Dean Moor Solar Farm

Applicant Response to Relevant Representations

12 August 2025
Prepared by: Stantec UK Ltd
PINS Ref: EN010155
Document Ref: D1.1
Deadline 1
Revision: 1

3c

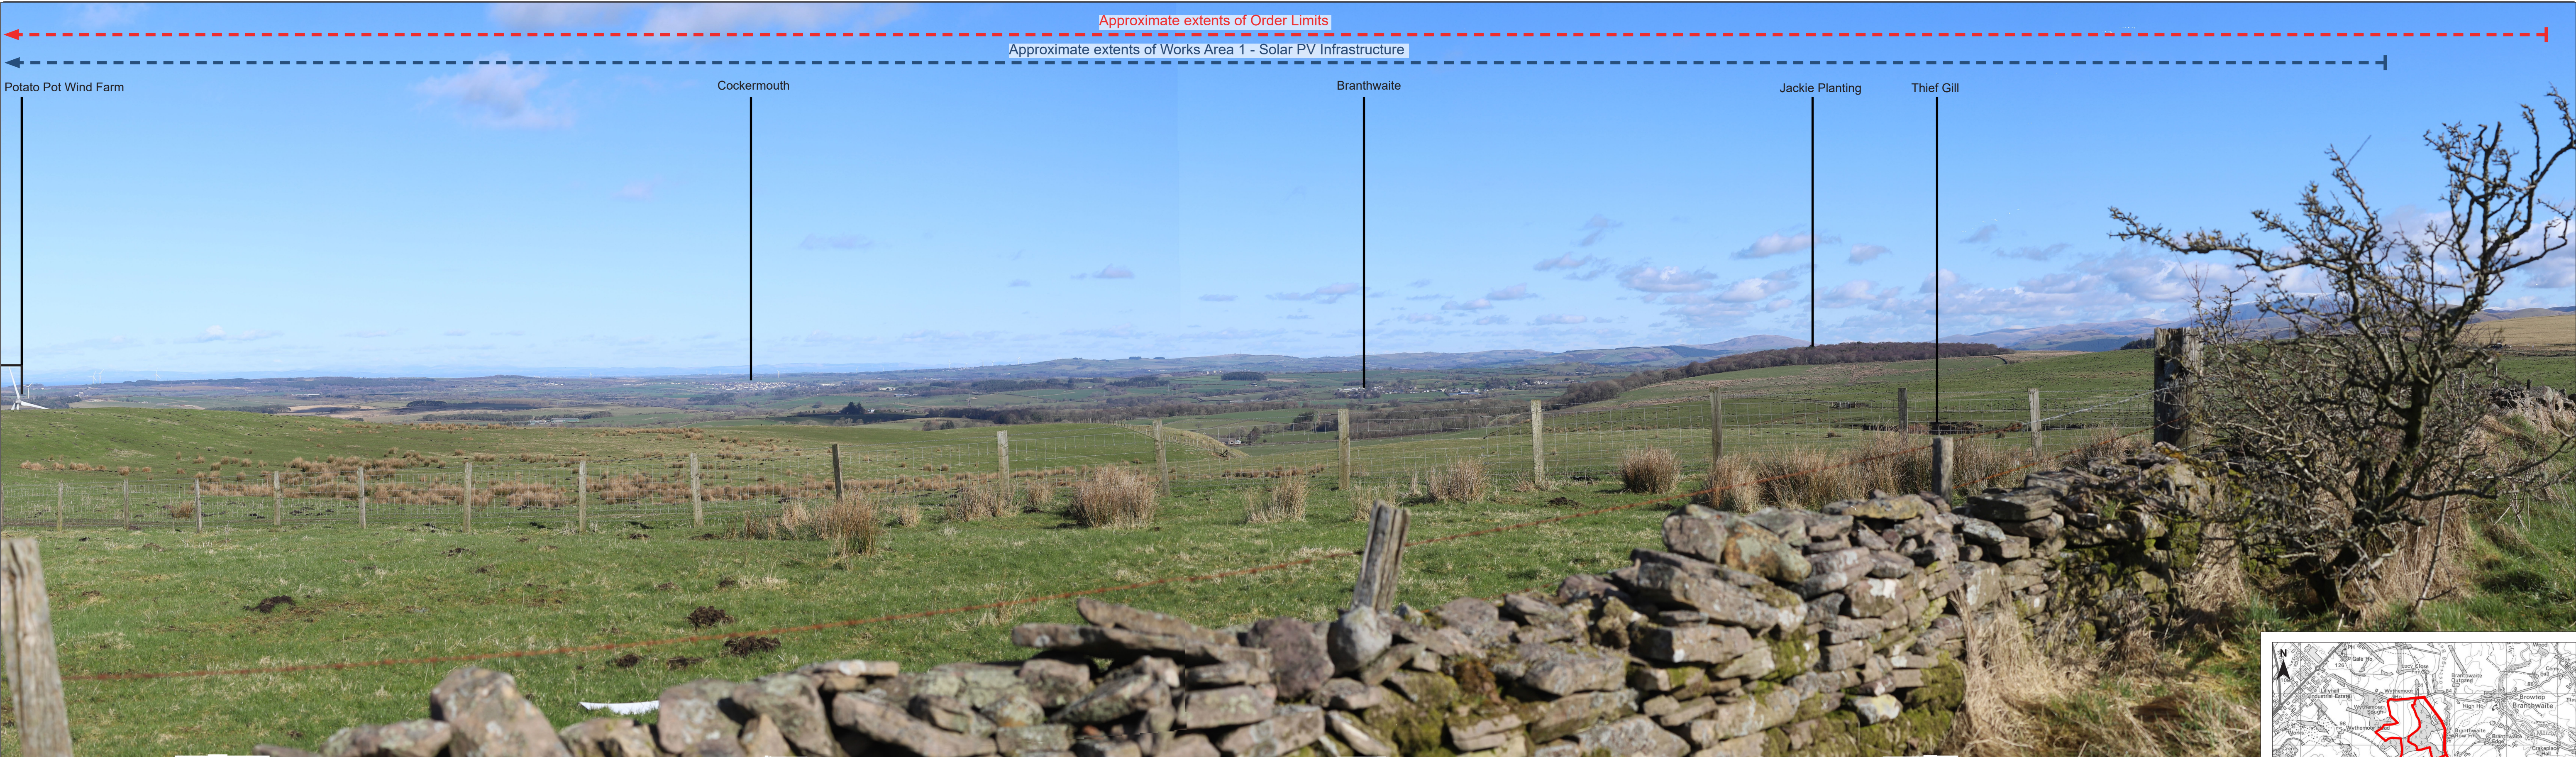
VP Table - VP2c	<p><i>Not the worst-case scenario viewpoint along this road route (VL3c). There would be a direct view across the Proposed Development from near the entrance of the Motocross Track which would be worst-case scenario views.</i></p> <p><i>The view chosen is representative of typical views from the road near the edge of the CRow open access land. The submitted report suggests this viewpoint is on an elevated plateau with 360-degree</i></p>	<p>The Applicant acknowledges the statement and that there could be a worsening of effects for users of the road as they travel further east. However, the Applicant considers that VL6b is broadly representative of available views further east along this road which is recognised by the Council (‘VL6b - It is also representative of the views of road users along this stretch of Dean Cross Road’).</p> <p>The Applicant does not consider VL3c to be misleading as it is representative of views experienced by road users travelling along Dean Cross Road, who experience differing level of visibility due to the variations in topography and vegetation, as represented by the ZTV analysis (ES Figure 7.5a [APP-085], ES Figure 7.5b [APP-086], and ES Figure 7.5c [APP-087]). Road users are generally medium sensitivity, however, this</p>
